Online Comment

Application H23-1296-16
Location White Cottage Cranesgate North Whaplode St Catherine PE12 6ST
Proposal Replacement dwelling

Name J Reith
Address Environmental Health Technician Safety and Environment

SITE LAYOUT PLAN,
1/500.

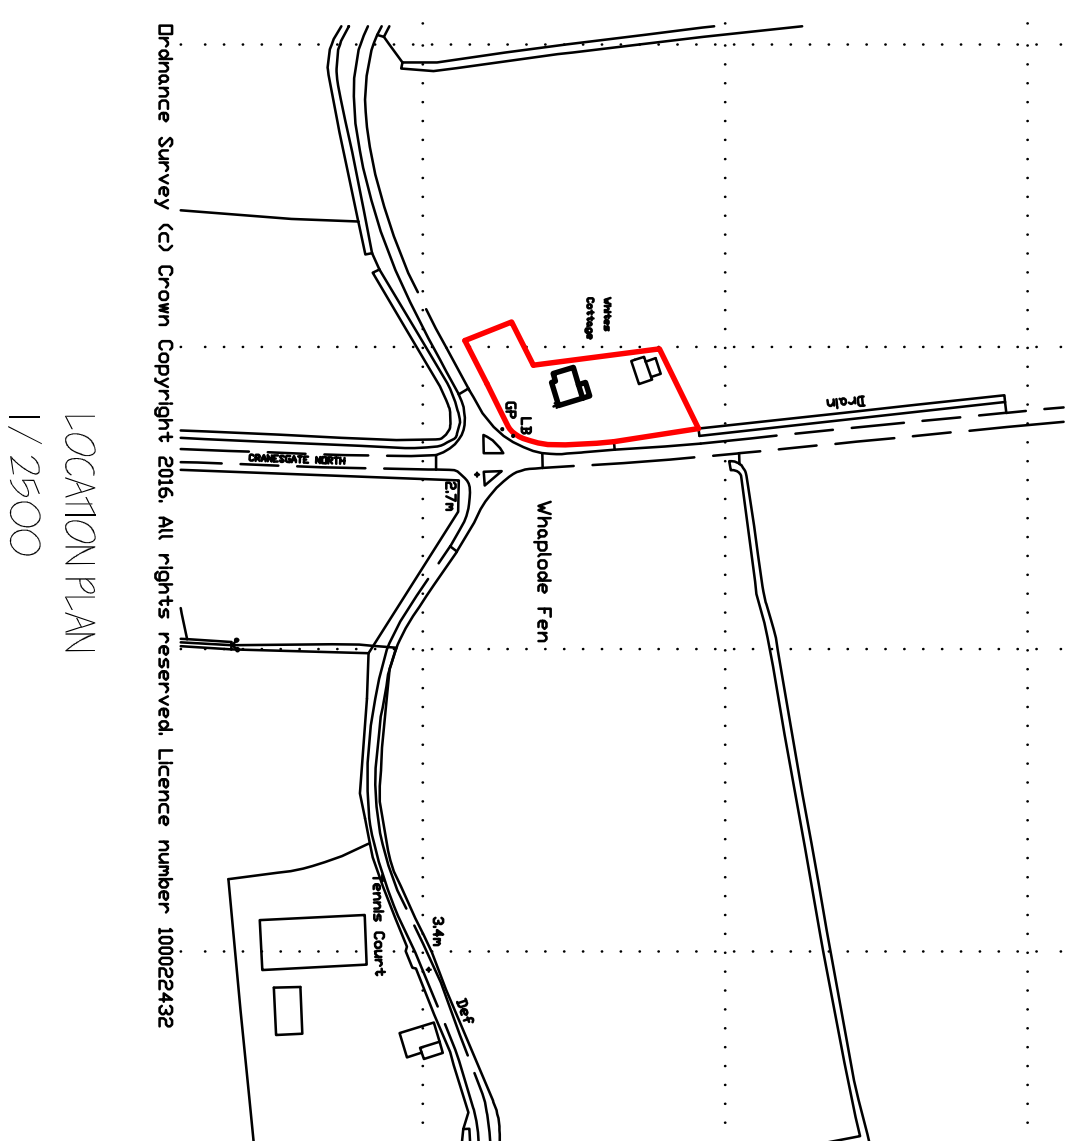
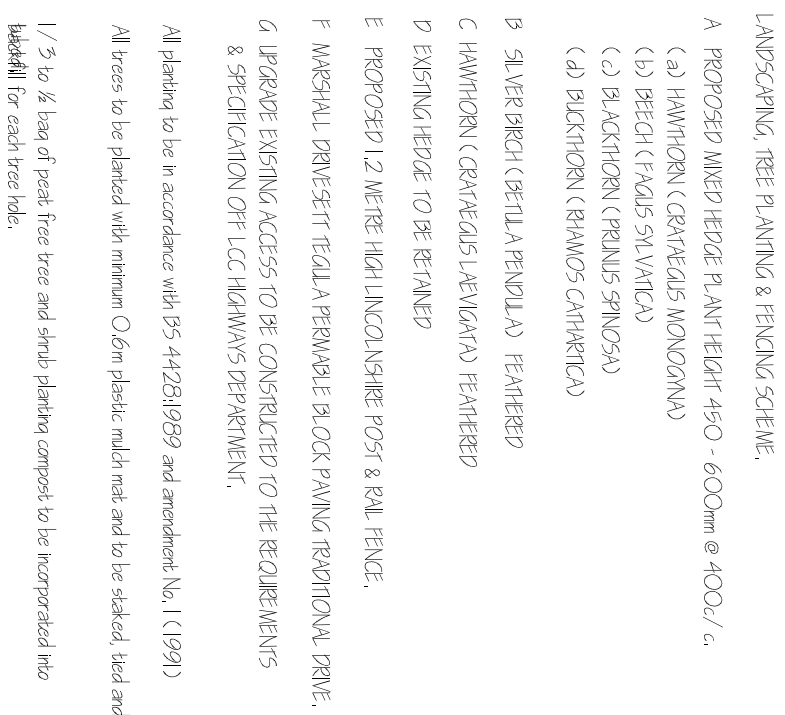
The condition relating to contaminated land on application H23-1170-15 was requested as we have a record of a filled pit/pond 50m south east of the site. The GeoEnvironmental Desk Study by Goldfinch Environmental Report Ref 0400/1 does not sufficiently investigate the filled ground. I therefore ask that the previous condition is carried over.
